National Highways Planning Response (NHPR 24-02) Formal Recommendation to an Application for Planning Permission

Council's Reference: 2024/92281

Location: Land adj, 17, Whitehall Road West, Birkenshaw, BD11 2LS

Proposal: Erection of 23 dwellings

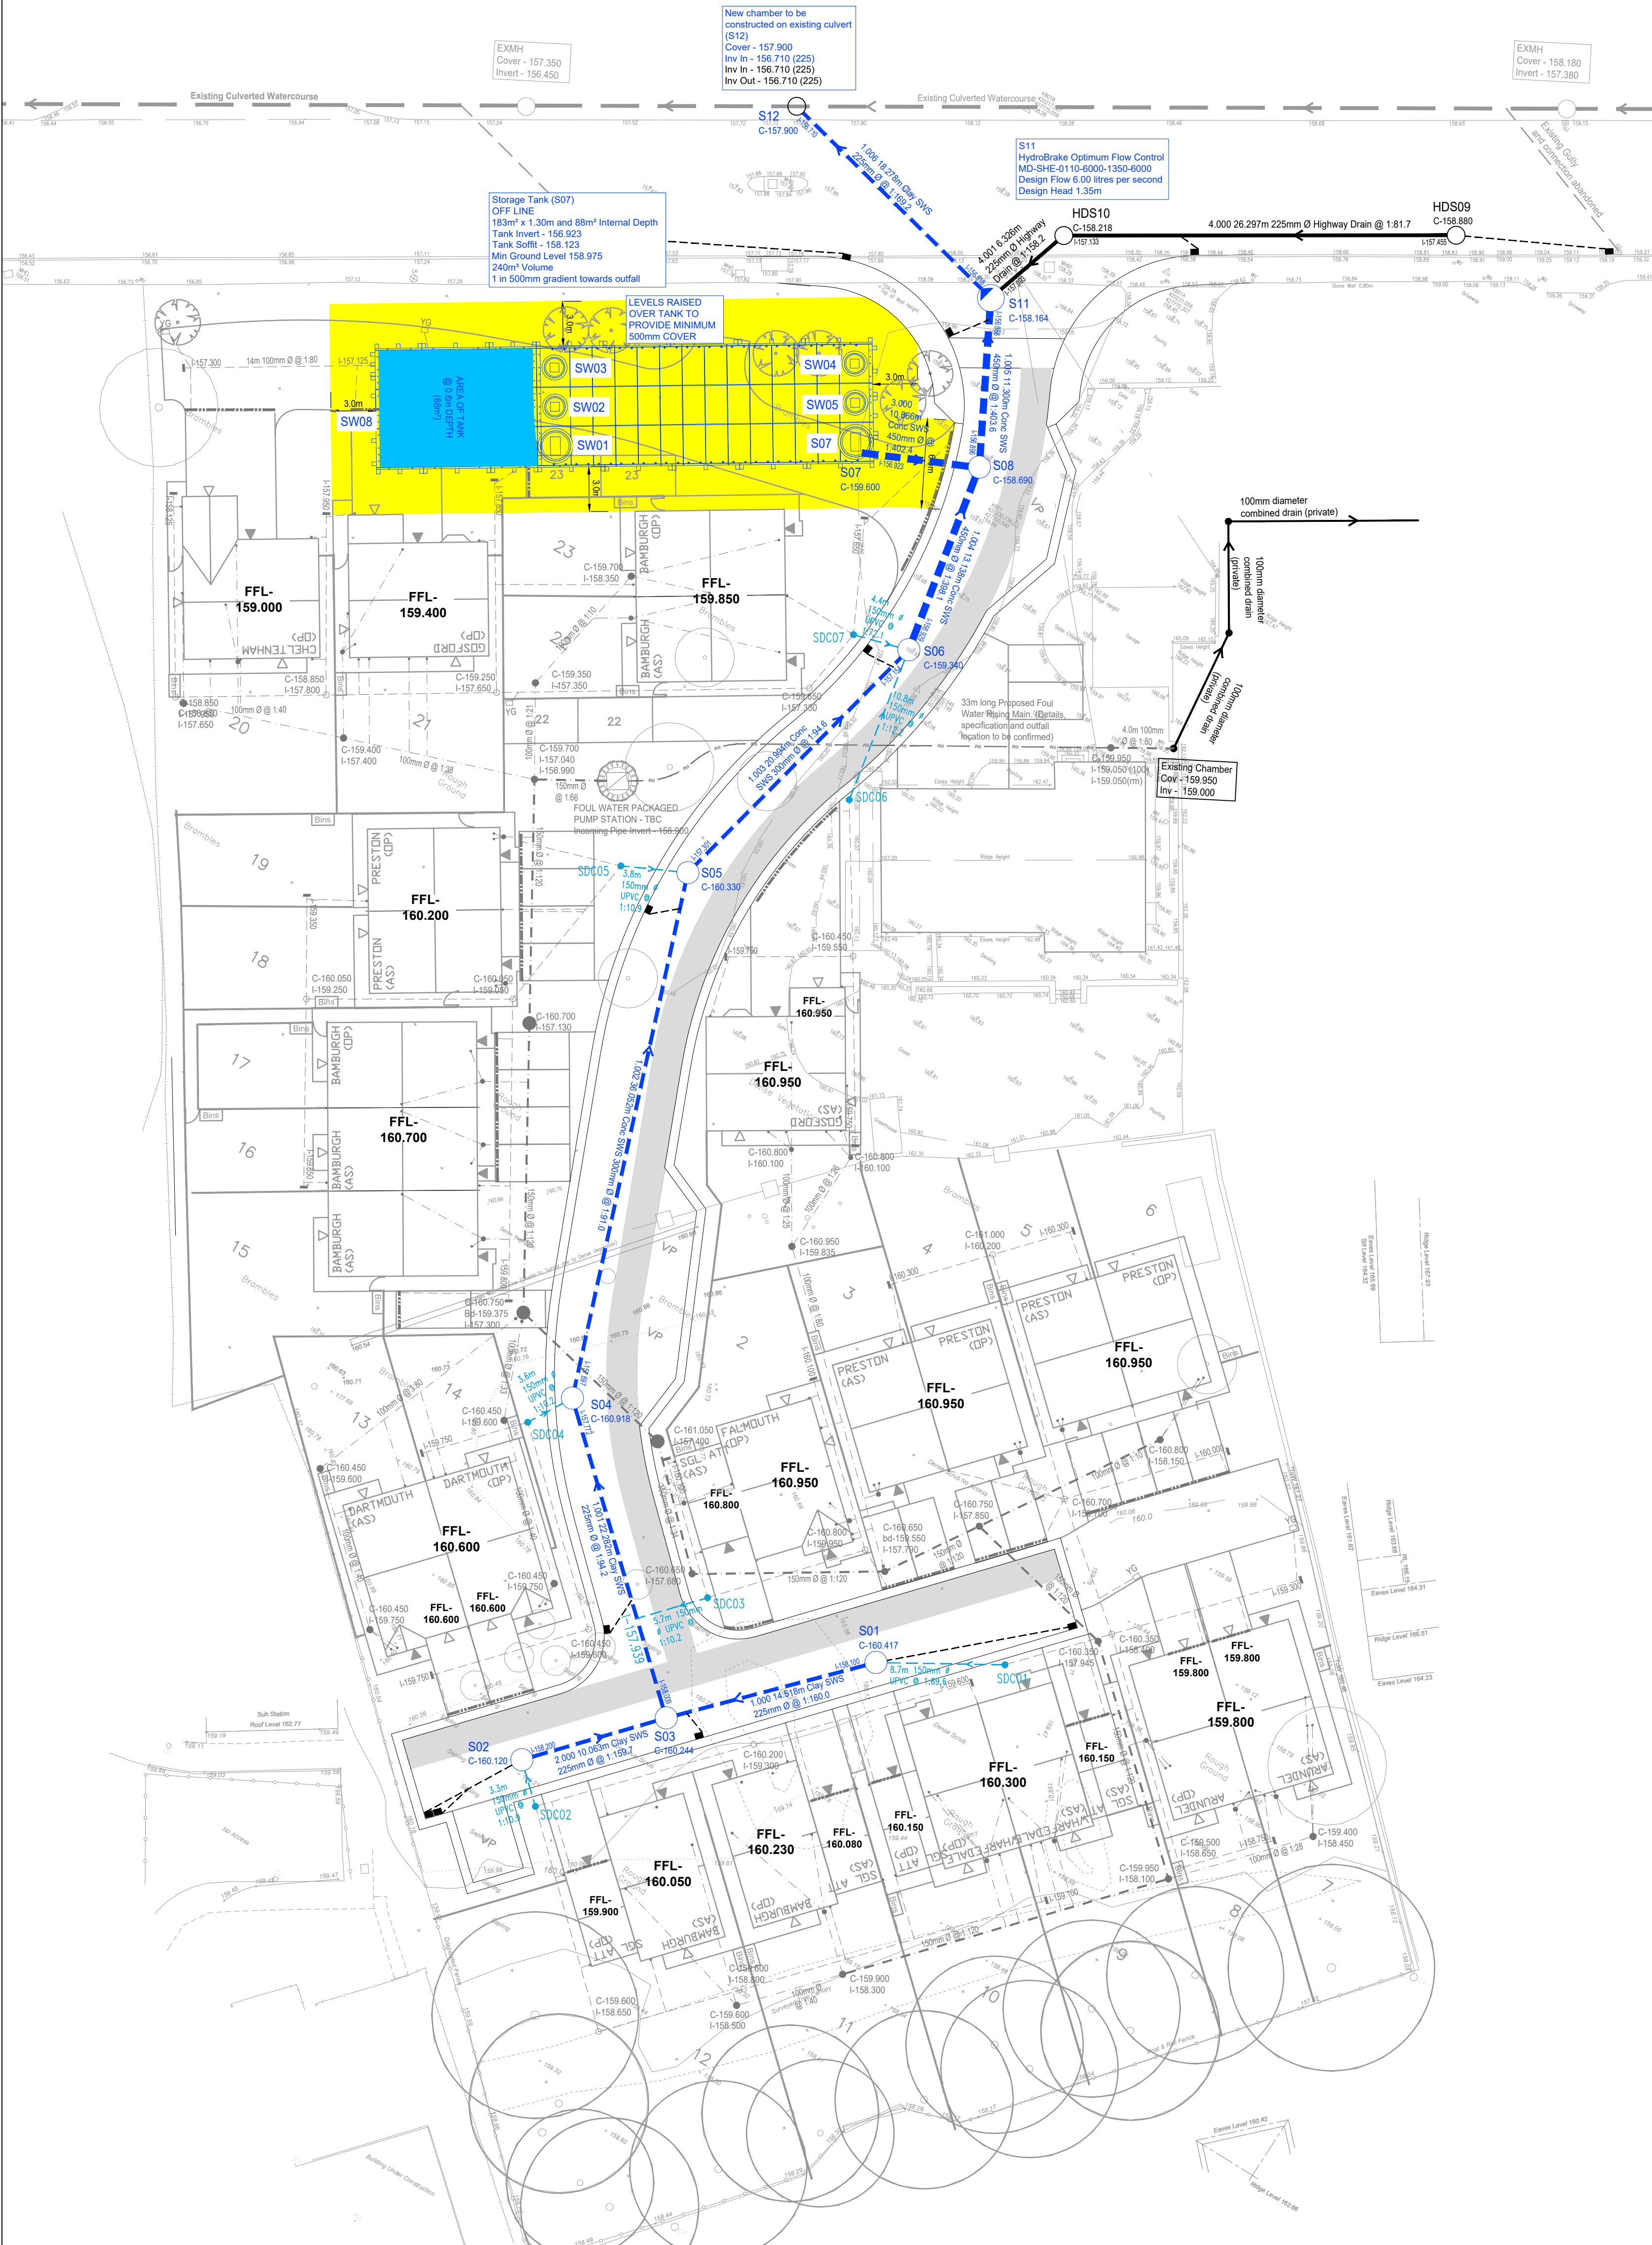
The surface water strategy agreed for these developments split the outfall between the northern and southern sections. The northern section outfall went via a Kirklees highways drain incorporating some existing highway (serving Whitehall Road West) which connects into the motorway drainage for the M62. The southern section connected to drainage provided as part of the adjacent Barratts David Wilson Homes Development without increasing flood risk in the locality.

This application amalgamates both areas and will connect both areas to highway drainage in Whitehall Road West which is a drainage system that already surcharges.

As such, National Highways require sight of the written justification requested by the Kirklees flood drainage lead for this change in surface water strategy prior to providing a response on this matter. The justification should clearly demonstrate that the proposed surface water strategy will not have a detrimental impact on the motorway highway drain.
